Our ref: DOC22/701639

Sender's ref: SSI-10055

Subject: Review of exhibited Environmental Impact Statement – Inland Rail (Albury to Illabo) (SSI-10055) - Flooding

ATTACHMENT A BCD Assessment Summary for Flooding - Environmental Impact Statement (SSI-10055)

FIGURE 2: ALBURY PRECINCT ENHANCEMENT SITES (SOURCE: ENVIRONMENTAL IMPACT STATEMENT)

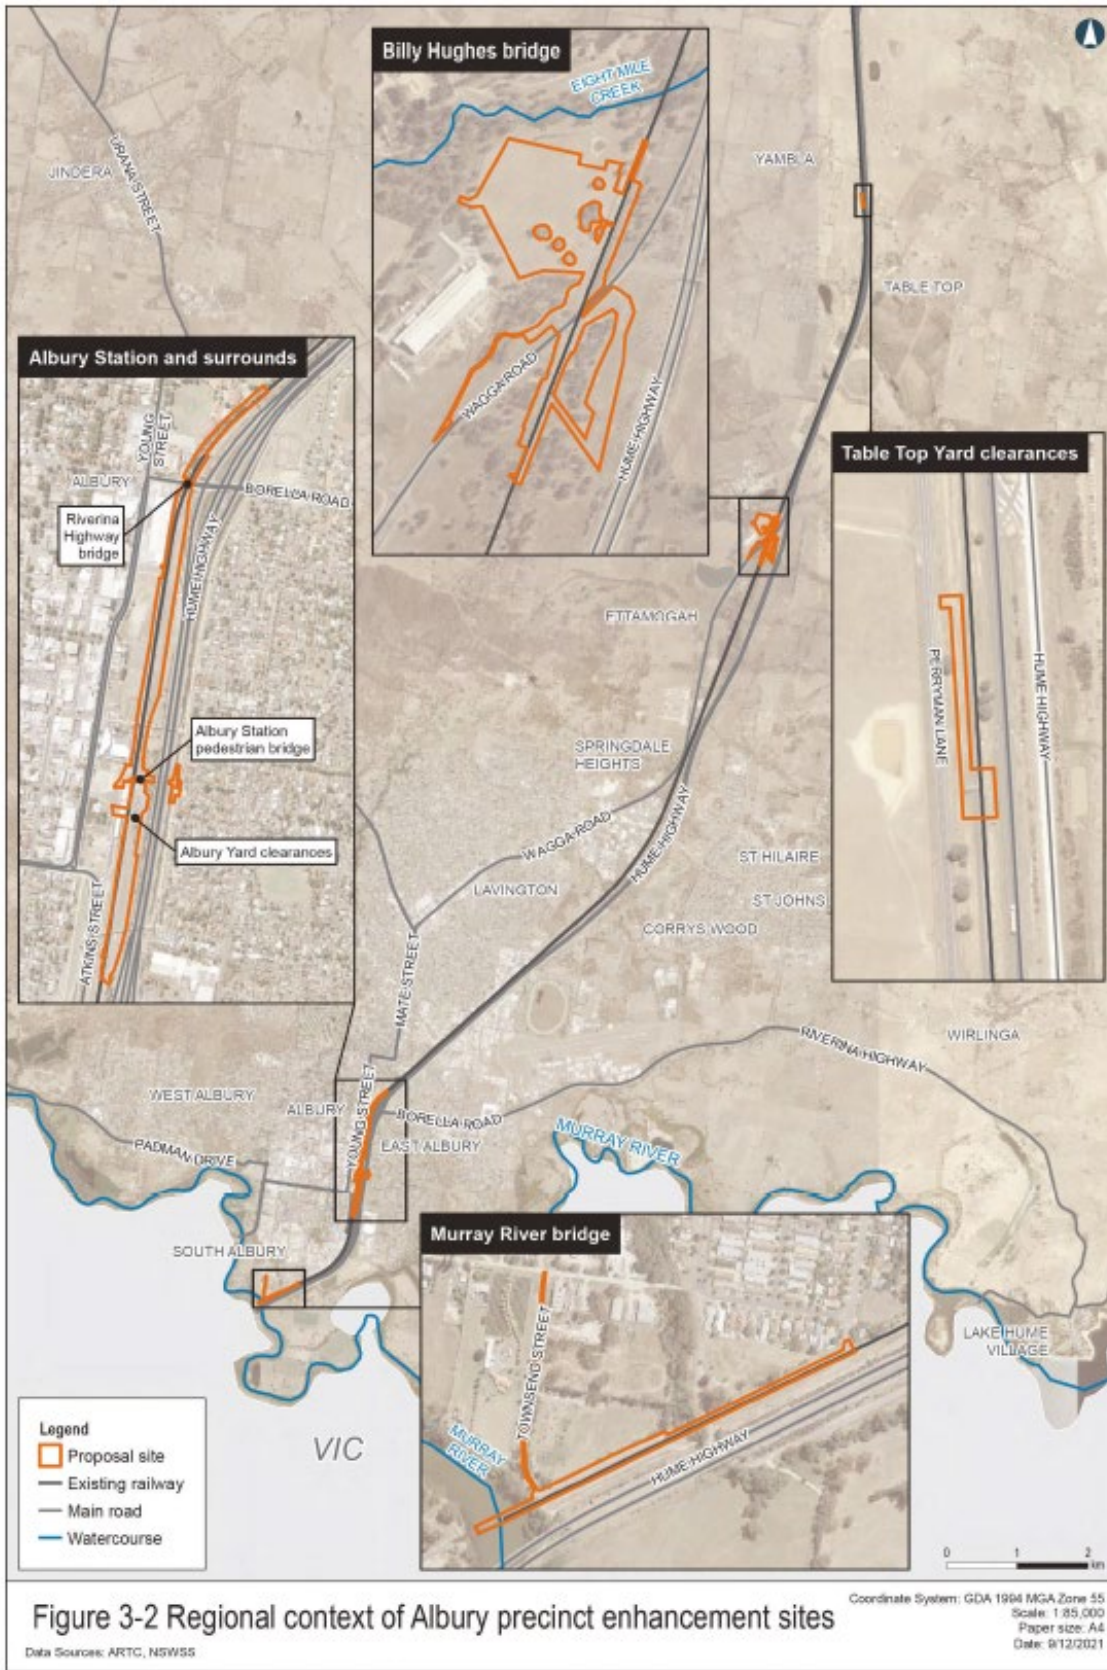
Section 5.1.2.1 of Technical Paper 11 states that the Riverina Highway track lowering section at Albury includes a stormwater storage and pump solution due to a lack of sufficient grade for gravity drainage. The proposed design and operation of this infrastructure is not clearly described, and flood impacts during its operation have not been quantified. The Albury CBD areas downstream from where the flows are to be discharged (Wilson Street) are a known flood hotspot that contain high density development that are particularly sensitive to increased flows.

- 1.1 A thorough assessment of the flood impacts during operation of the Riverina Highway enhancement site must be completed in the detailed design stage to ensure the downstream impacts do not exacerbate the existing flood risks through the Albury CBD. Albury City Council must be extensively consulted throughout this process.

FIGURE 4: WAGGA WAGGA PRECINCT ENHANCEMENT SITES (SOURCE: ENVIRONMENTAL IMPACT STATEMENT)

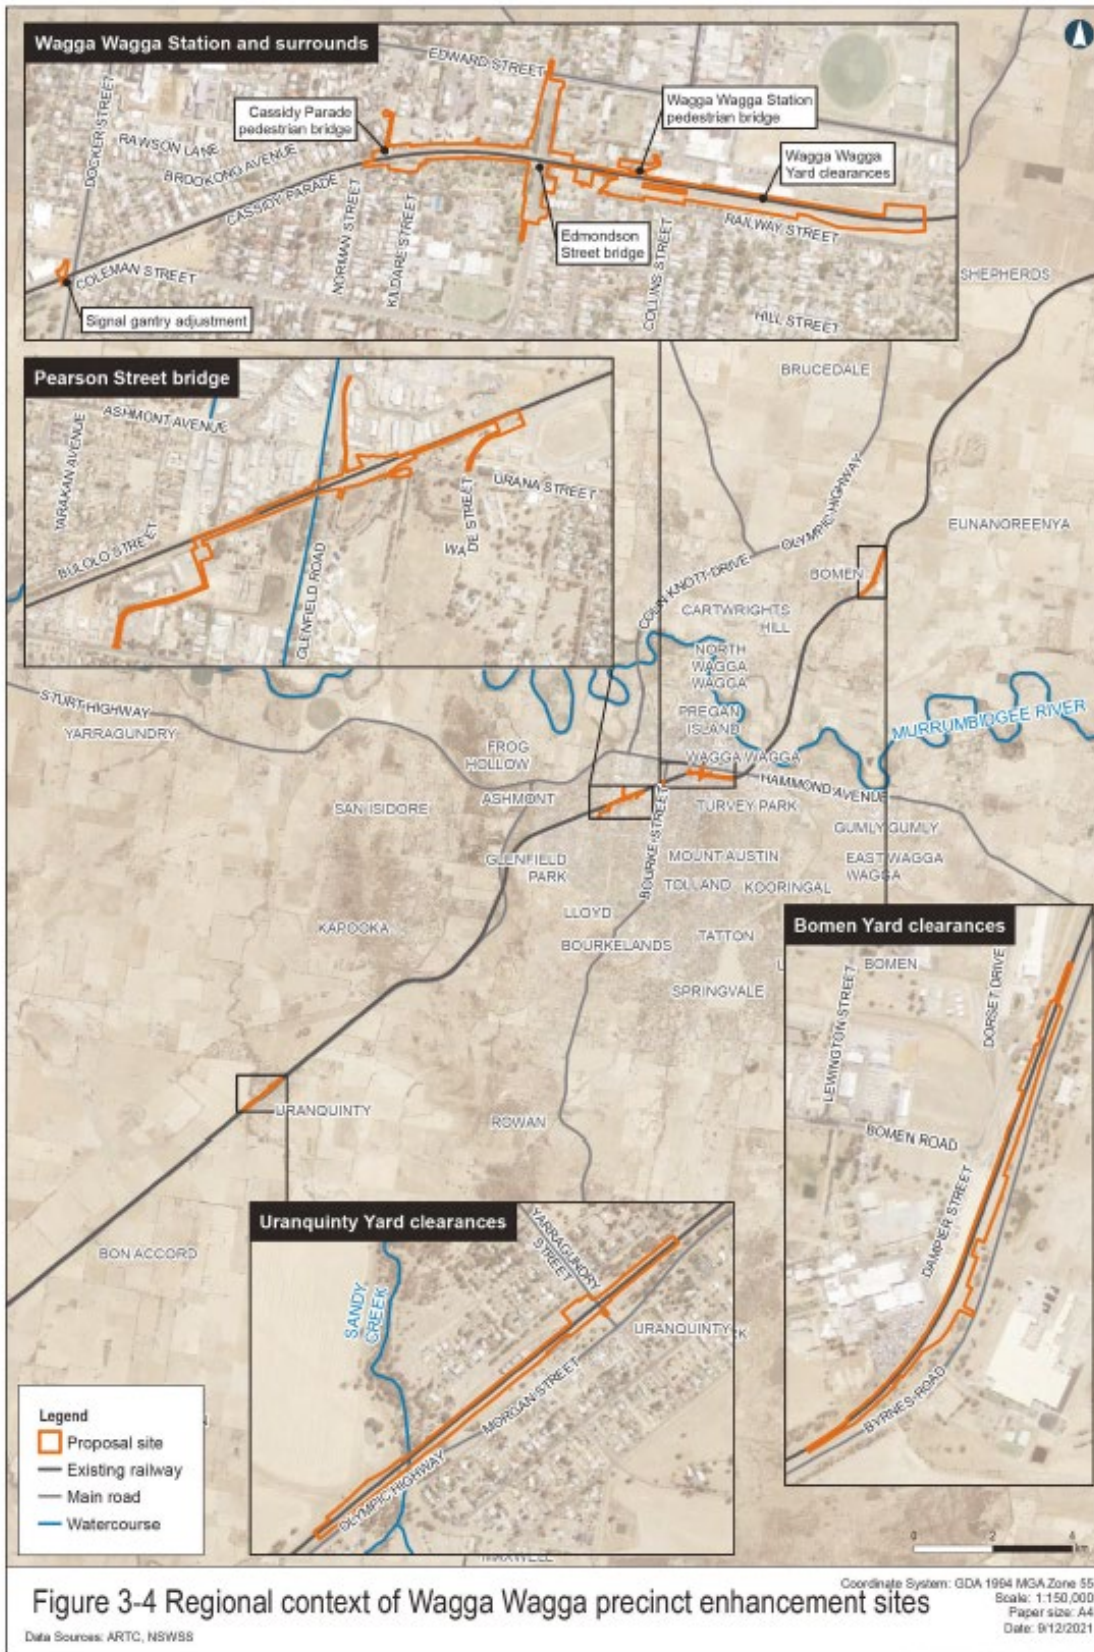
The Uranquinty Yard enhancement site includes the raising of a section of the rail that is already overtopped in major flood events, and modifications to the Sandy Creek rail bridge (Section 5.1.2.3 of Technical Paper 11). Although the impact assessment states that the flood model results show impacts are negligible and are compliant with the Quantitative Design Limits (QDLs), details of the extent of the proposed modifications to the rail bridge/embankment and the impacts on flood flows are unclear and the modelling methodology is ambiguous. ARTC must also demonstrate that the modelling methodology that compares the existing scenario with the proposed enhancement works is consistent in its approach. In addition, given that Wagga Wagga City Council is currently designing an upgrade for the levee system that protects the town, it is important that these design projects are completed in collaboration to ensure they are complementary. In this way the resultant flood impacts and risks can be minimised once they are both constructed, and where possible flooding outcomes can be optimised.

The Pearson Street rail lowering site works described in section 5.1.2.3 of Technical Paper 11 involve several major drainage changes that have the potential to exacerbate flooding conditions, particularly when the Glenfield Drain is at or near capacity. Wagga Wagga City Council are in the process of investigating options for mitigating floods in the Glenfield Drain catchment which include possible modifications to the drainage lines through the rail corridor to alleviate local flooding risks.

The flood impact assessment of the Wagga Wagga Yard site in section 5.1.2.3 of Technical Paper 11 shows a flood afflux that exceeds the QDLs in the industrial area to the east of the site. However, it has been correctly identified that a major culvert is missing from the original hydraulic model sourced from Wagga Wagga City Council for use in the impact assessment. It is proposed that the flood model will be updated at the detailed design stage to include the drainage and culvert in the model to confirm the true afflux result. Further, the assessment states that the model update will likely result in only a minor afflux compared to that currently described. The update to the model and resulting impact must be included in the Response to Submissions report rather than postponed to detailed design, so that the actual flood impacts are understood prior to approval.

- 2.1 Response to Submissions report to clarify the proposed modifications to the Sandy Creek rail bridge and embankment, including confirmation of flood impacts resulting from any changes to the existing structures. This must include details on the hydraulic modelling methodology used to ensure that a consistent approach has been used when assessing the impact of any changes to the rail line.
- 2.2 A cumulative impact scenario for the 1% Annual Exceedance Probability (AEP) must be undertaken with the proposed levee in place.
- 2.3 ARTC to work closely with Wagga Wagga City Council in the detailed design stage to ensure consistency with the Uranquinty levee upgrade project.

- 3.1 ARTC to work closely with Wagga Wagga City Council in the detailed design stage to ensure the project complements the Glenfield Drain Flood Mitigation project.

- 4.1 The existing culvert at the Wagga Wagga Yard site must be included in the hydraulic model, and the flood impact assessment (including confirmation that the QDLs are not exceeded) must be updated for the Response to Submissions report.
